North Ryde Station Urban Activation Precinct M2 Site (SSD_5093)
Proposed Modification

Comment by DPI Water

Attachment A
North Ryde Station Urban Activation Precinct (SSD_5093)
Proposed Modification
Additional comments by DPI Water

Figure 4: proposed location of gas pipe relative to Porters Creek headwall and stormwater drain.

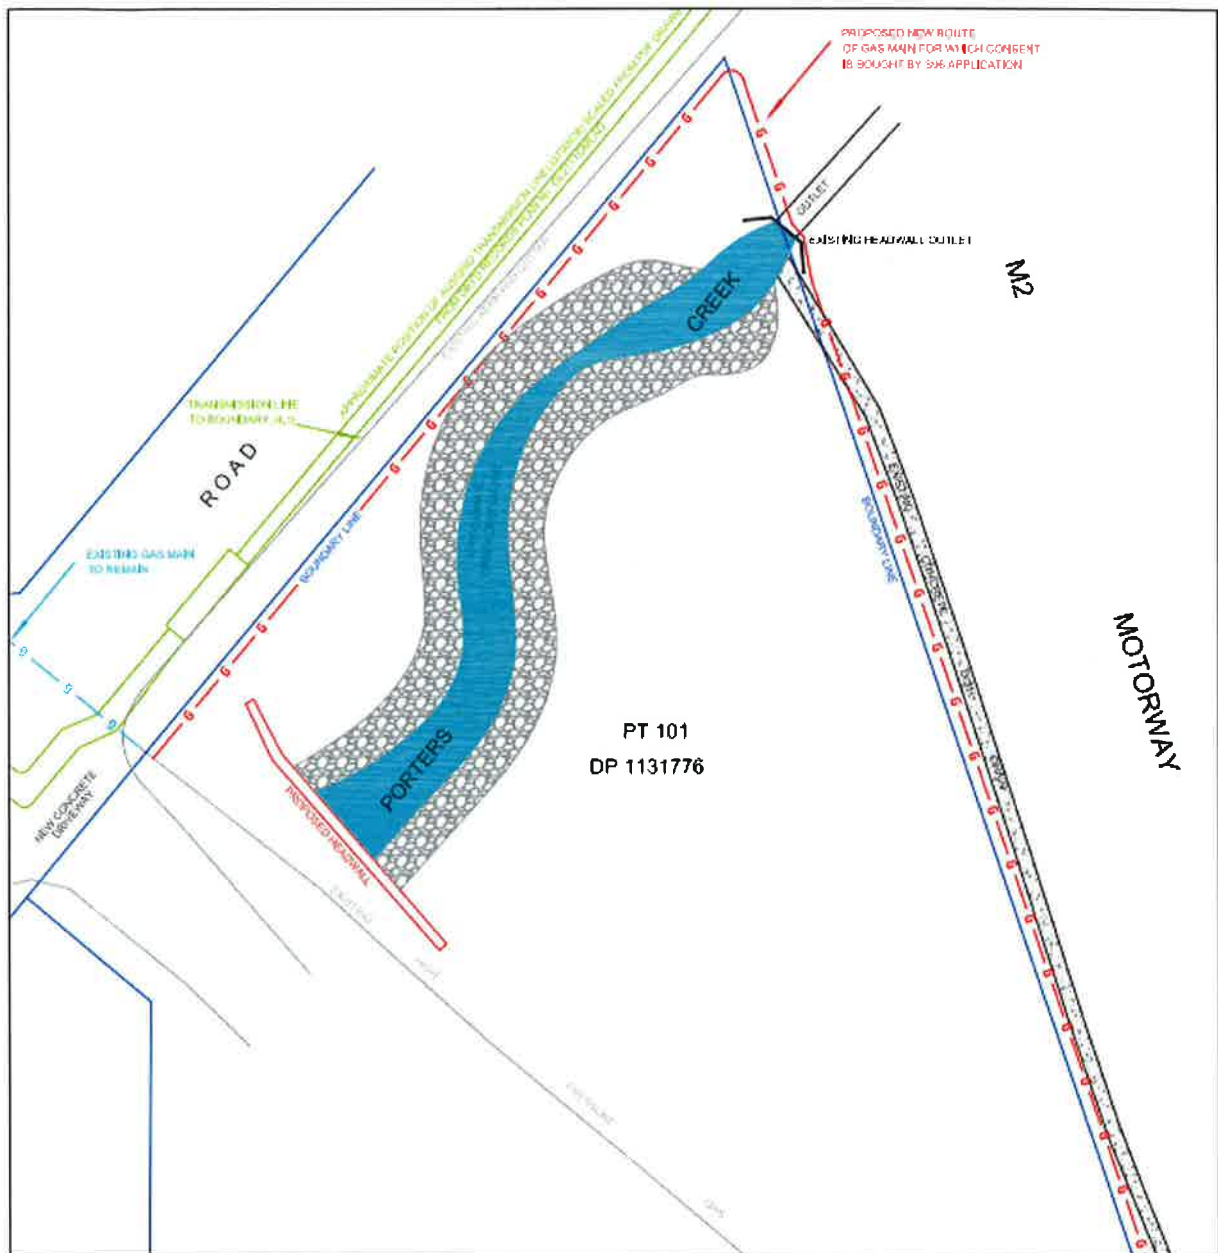
The MOD 1 proposal needs to clarify if the proposed gas pipeline alignment will cross Porters Creek and disturb the riparian corridor, as the MOD 1 application and the RTS for SSD-5093 seem to provide conflicting advice in relation to whether the proposed gas pipeline alignment will cross the creek.

The Mod 1 application needs to clarify if the proposed gas pipeline alignment will cross Porters Creek and disturb the riparian corridor. It is recommended a colour scaled plan is provided which shows the location of the proposed new gas pipeline route, Porters Creek, the 30m wide riparian corridor either side of the creek and the artificial drainage line.

If the pipeline route is to cross Porters Creek, the MOD 1 application needs to provide details including:

- the crossing method,
- information on the creek bed and banks at the crossing (eg are the banks stable or unstable; is the creek bed bedrock or a sand bed etc),
- an assessment of potential impacts of the proposal on the creek and riparian corridor,
- mitigation measures.

FIGURE 2 – PLAN OF PROPOSED GAS MAIN RELOCATION (REFERENCE: C-0-9-20)

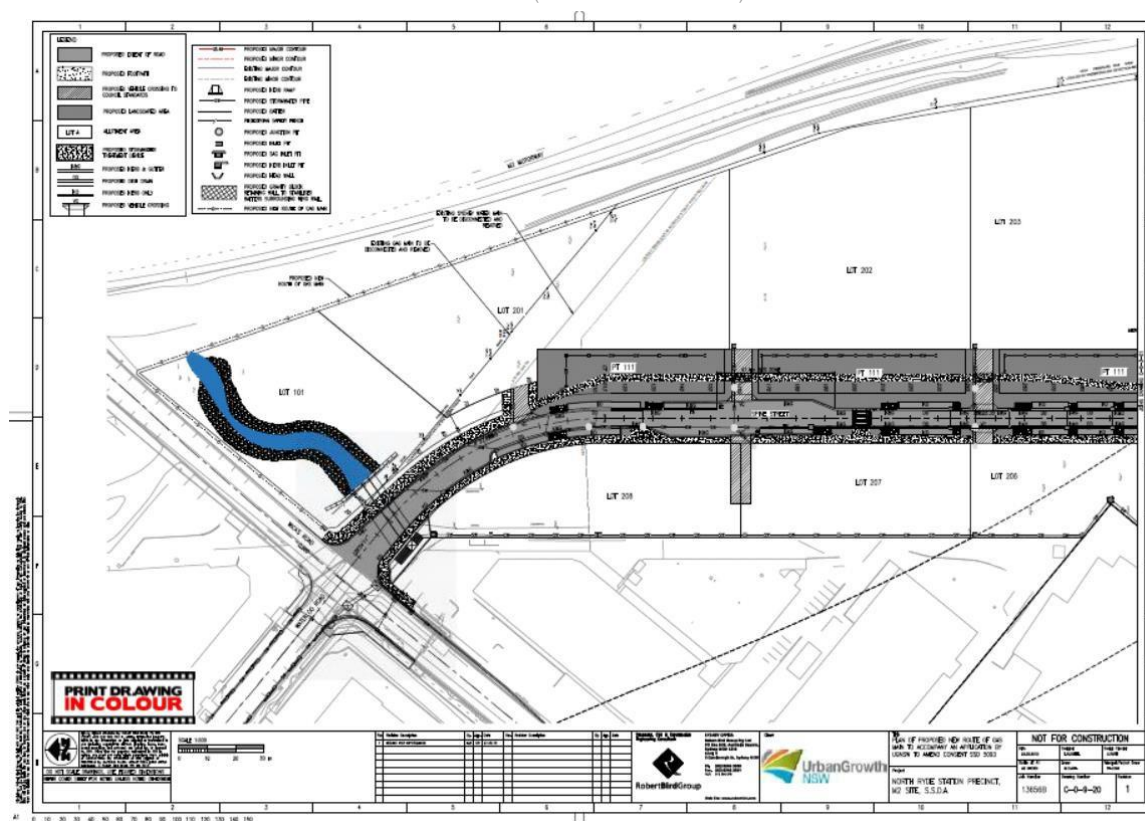
Attachment A to MOD 1 appears to show the proposed new gas pipeline will cross Porters Creek and the riparian corridor. The RTS for SSD-5093 indicates the gas main relocation would involve works across Porters Creek and notes at the creek, a temporary bund wall would be constructed across the creek and a trench is to be excavated in the bedrock across the creek (Section 2.3.1, page 29).
